Arun District Council  
Arun Civic Centre  
Maltravers Road  
Littlehampton  
West Sussex BN17 5LF  
Planning & Building Control General Enquiries  
Tel: (01903) 737756 Fax: (01903) 730442  
Dx: 57406 Littlehampton  
Minicom: 01903 732765  
e-mail: [planning@arun.gov.uk](mailto:planning@arun.gov.uk)  
website: [www.arun.gov.uk/planning](http://www.arun.gov.uk/planning)

Application No: A/142/25/DOC  
Site Address: Wilmington Arundel Road Angmering BN16 4ET  
Description of works: Approval of details reserved by condition imposed under A/44/24/PL relating to condition 3 - Biodiversity Enhancement Layout.

Project	Gatehouse, Angmering	Date	Oct 2025	Drawing No.	CSA/6521/102
Drawing Title	Ecological Enhancements Plan	Scale	Refer to scale	Rev	A
Client	JW Stratton	Drawn	JR	Checked	JR

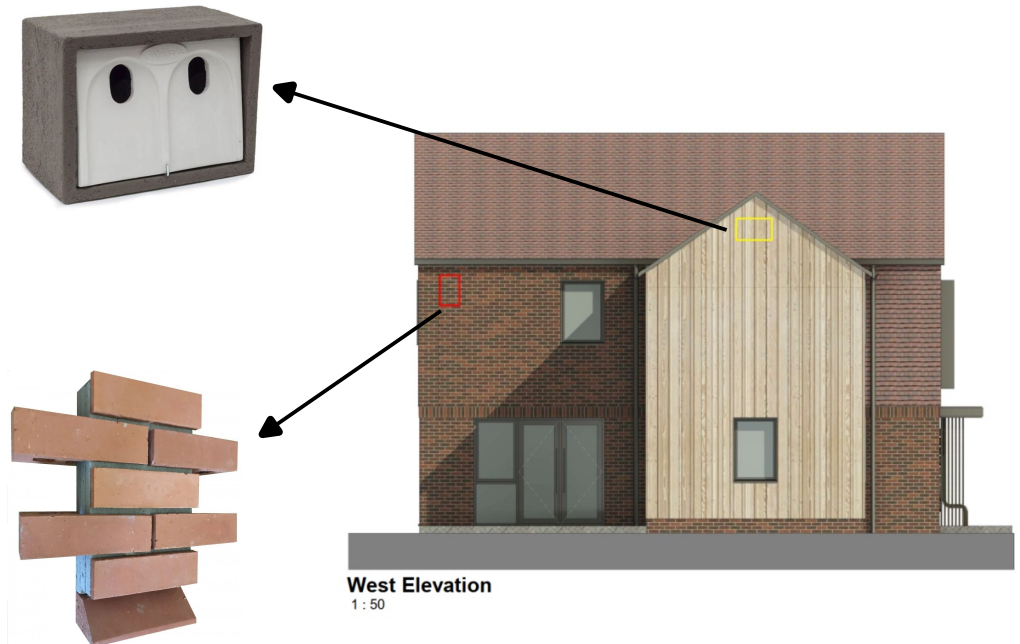
APC supports the statement by Ecology. However, condition 3 clearly states that "prior to any development above damp-proof course level a Biodiversity Enhancement layout providing the finalised details and locations of the enhancement measures contained within the preliminary ecological appraisal shall be submitted and approved". APC must point out that full construction has been made prior to this layout being submitted.
